HTE# BRES 2011-001Z

EXISTING SEPTIC SYSTEM INSPECTION

ADDRESS 1364 Rossea Pittman RD Broadway N.C. 27505

Drawing file: BRES2011-0012 / Approved 1364 Rosser Pittman.pdf

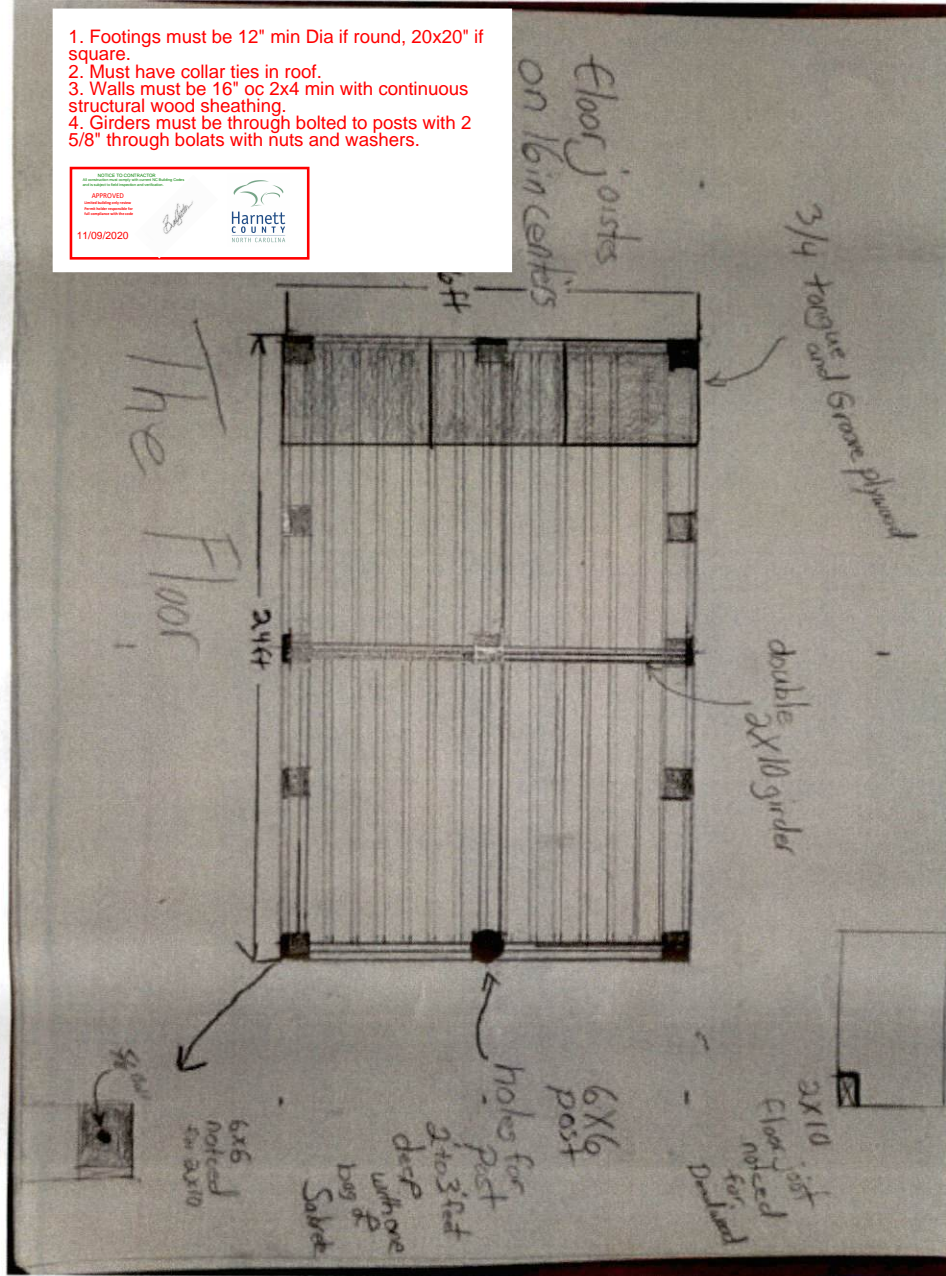
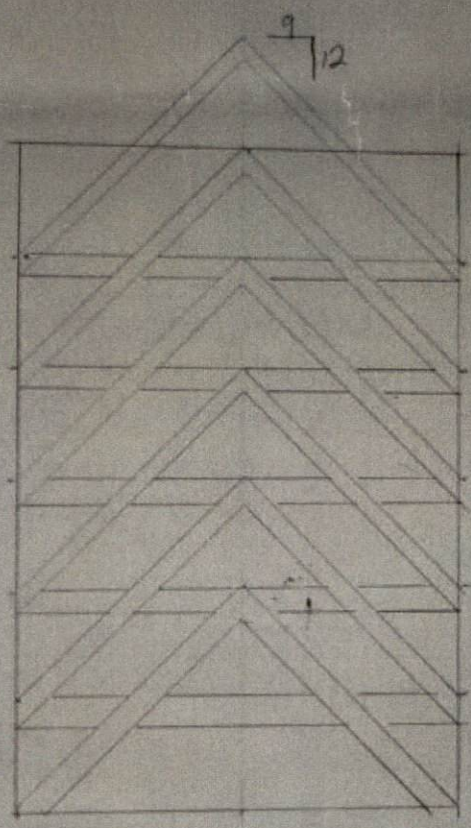
14X24 STORAGE BLDG
ALREADY STARTED
Building

BUILDING MUST BE 5' FROM ANY PART OF SEPTIC SYSTEM
DO NOT DRIVE OR PARK ON SEPTIC SYSTEM
